Application No. H19/0211/03/A1

Revised siting of proposed bungalow

**Planning Application Ref. H19/0211/03 – Bungalow and detached garage
Plot 2, South Eau Bank, Gedney Hill.**

EAST ELEVATION

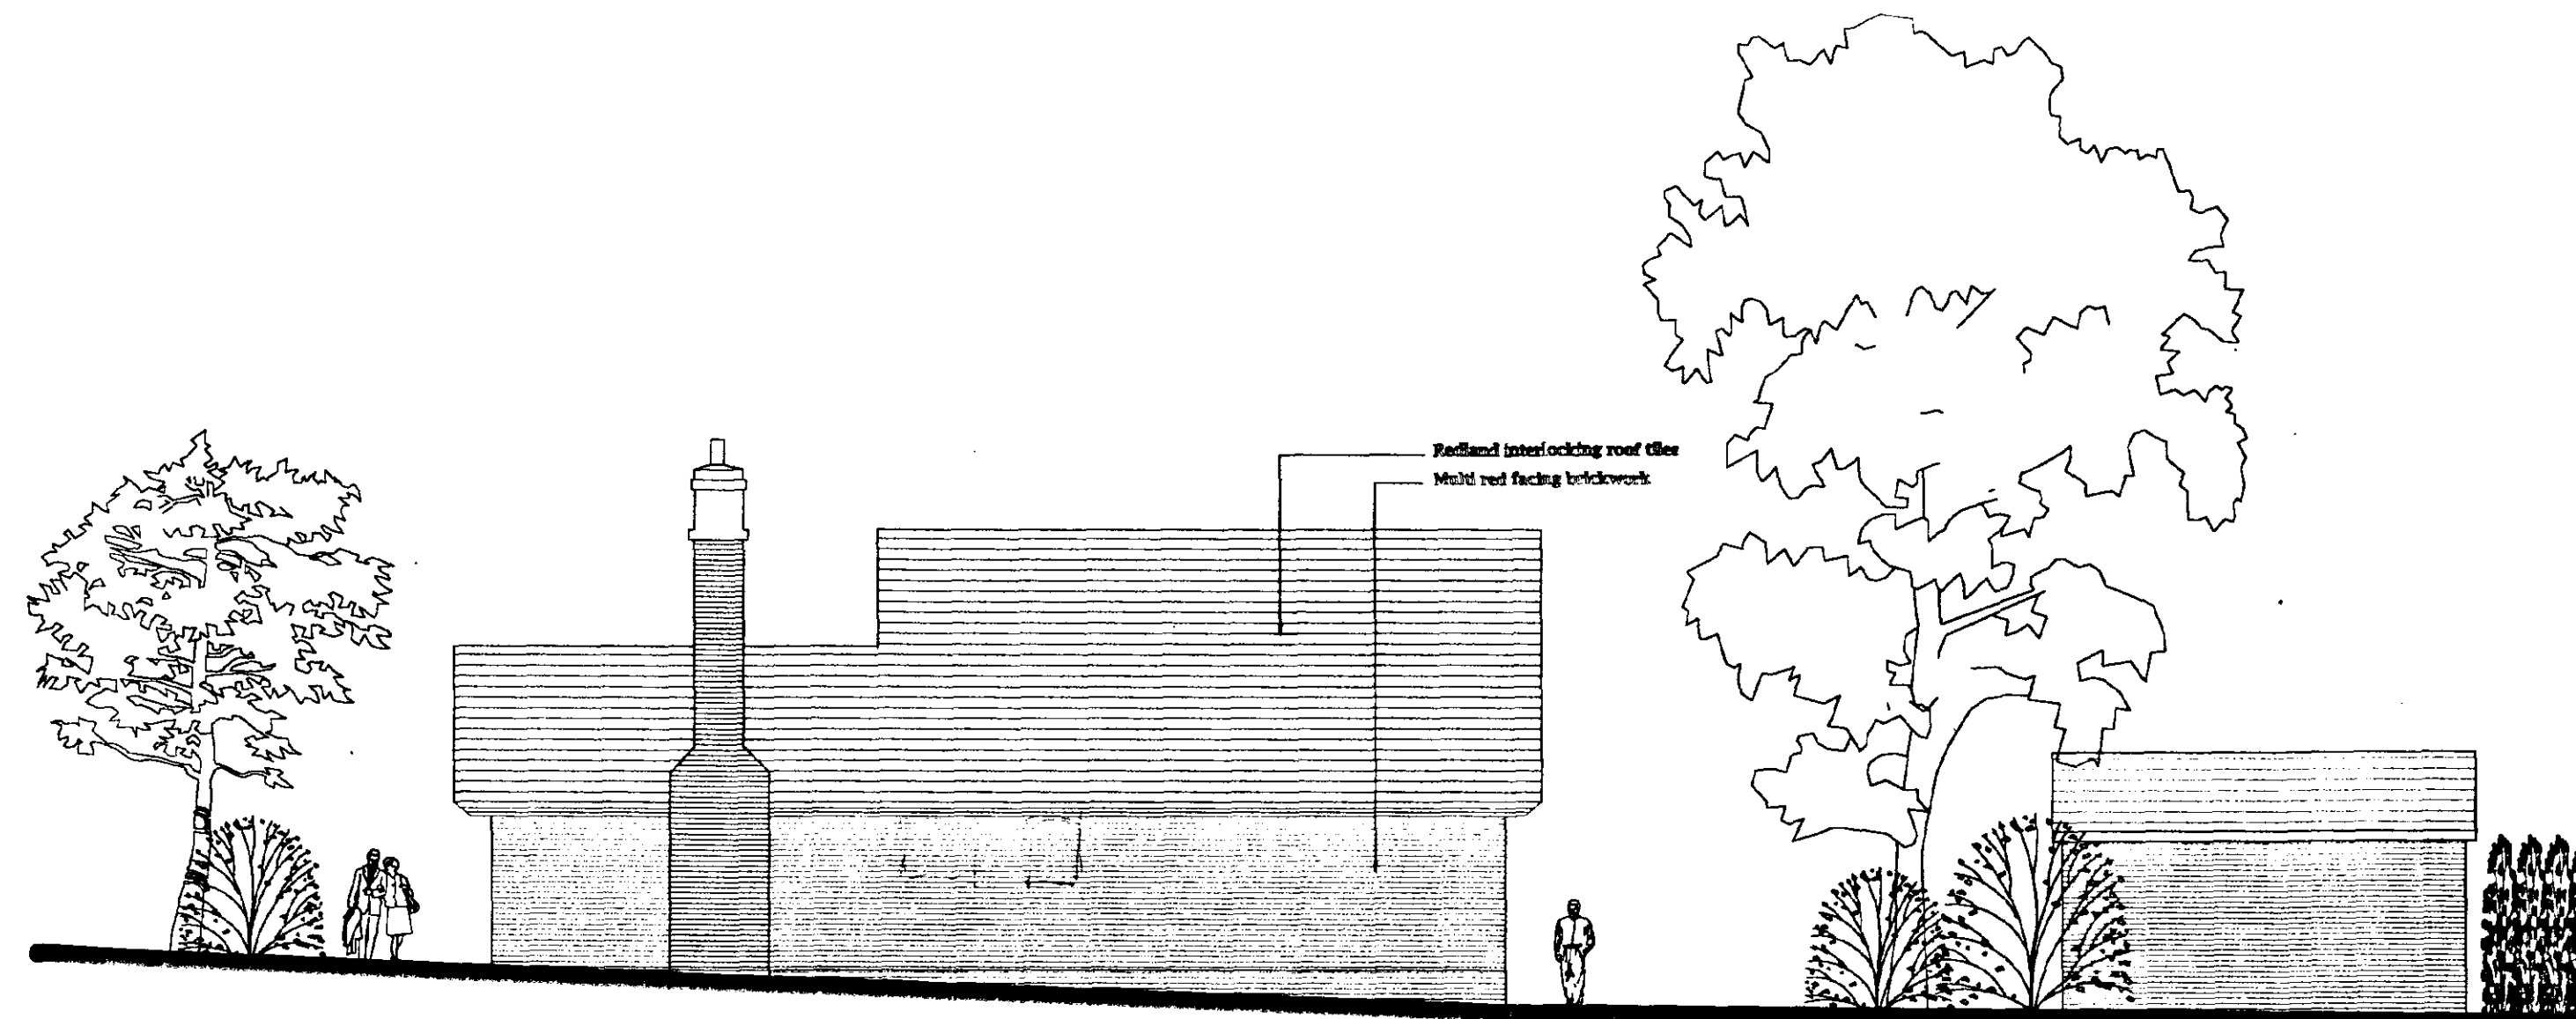
I have discussed the matters which you have raised with my clients and they are agreeable to the changes which you have recommended. We have therefore positioned the bungalow 500mm further from the eastern boundary and moved it towards the rear. In taking the turning bay to the front of the plot, we have moved the bungalow further to the rear than your letter might suggest. On balance we feel that this is a worthwhile improvement and would hope that this enables you to release a permission.
